Subject: 31 Fore Street Redevelopment  
Comment Response Letter

To facilitate the review, City and reviewer comments are provided on separate pages below in italics followed by Acorn Engineering, Inc.'s response. The comments were attached to the City Planning Division's Memo dated February 5<sup>th</sup>, 2016.

FOUNDATION DRAIN DETAIL
NOT TO SCALE

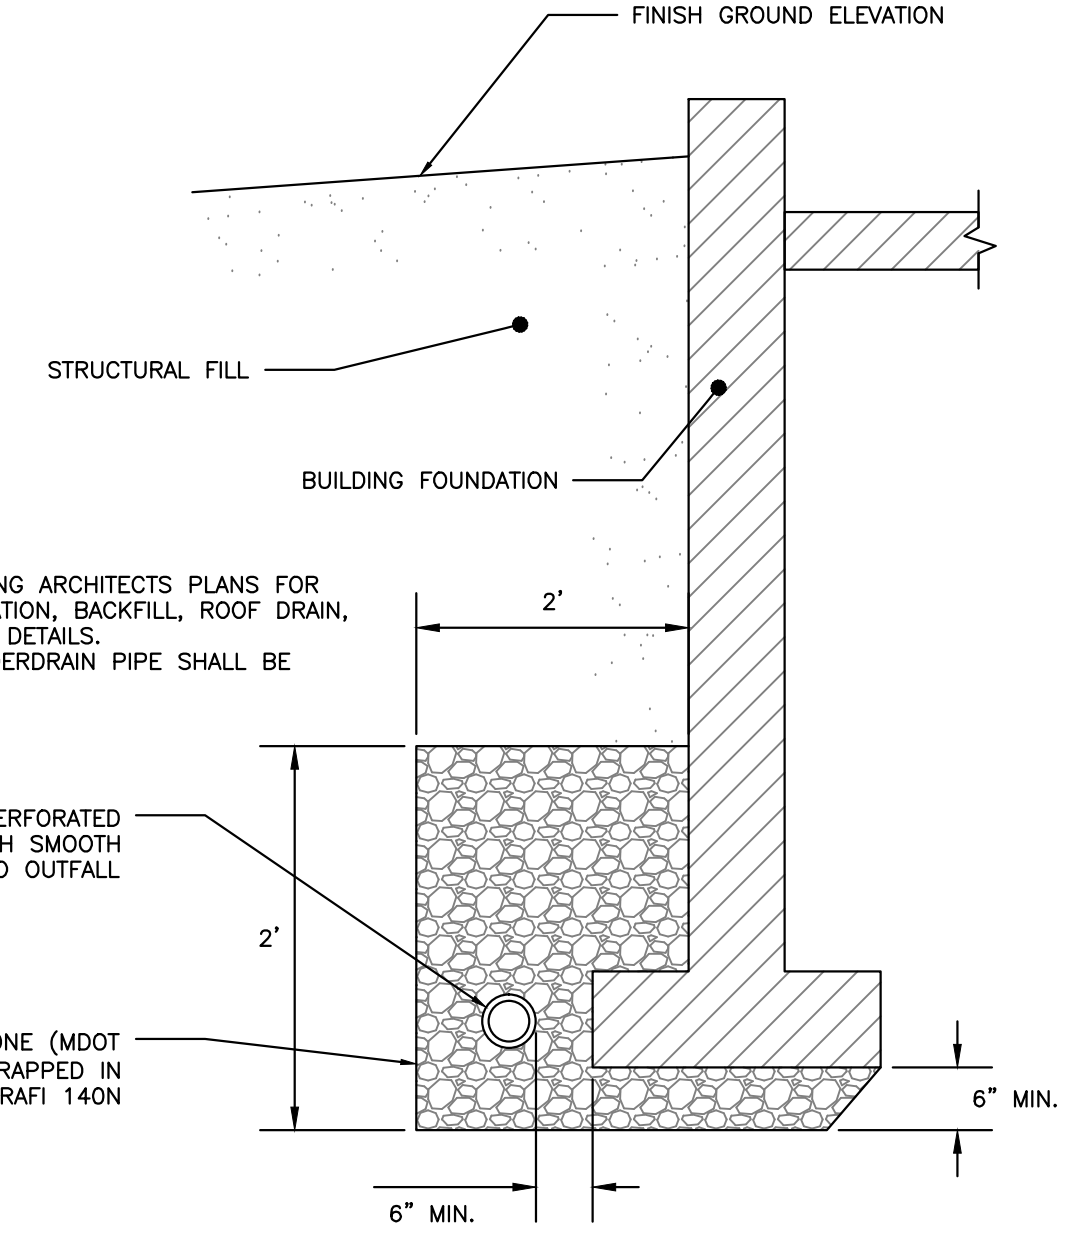
**Comment** – *Future plans should indicate the location and connection point for the building foundation drain; this connection can be combined with the storm drain discharge from the site if preferable, but should not be combined with the sewer pipe discharge from the site.*

**Response** – C-30 has been updated to reflect the foundation drain connection to the 6" Stormdrain outlet from the rain garden; the stormwater flow then outlets to the existing catch basin on Waterville Street.
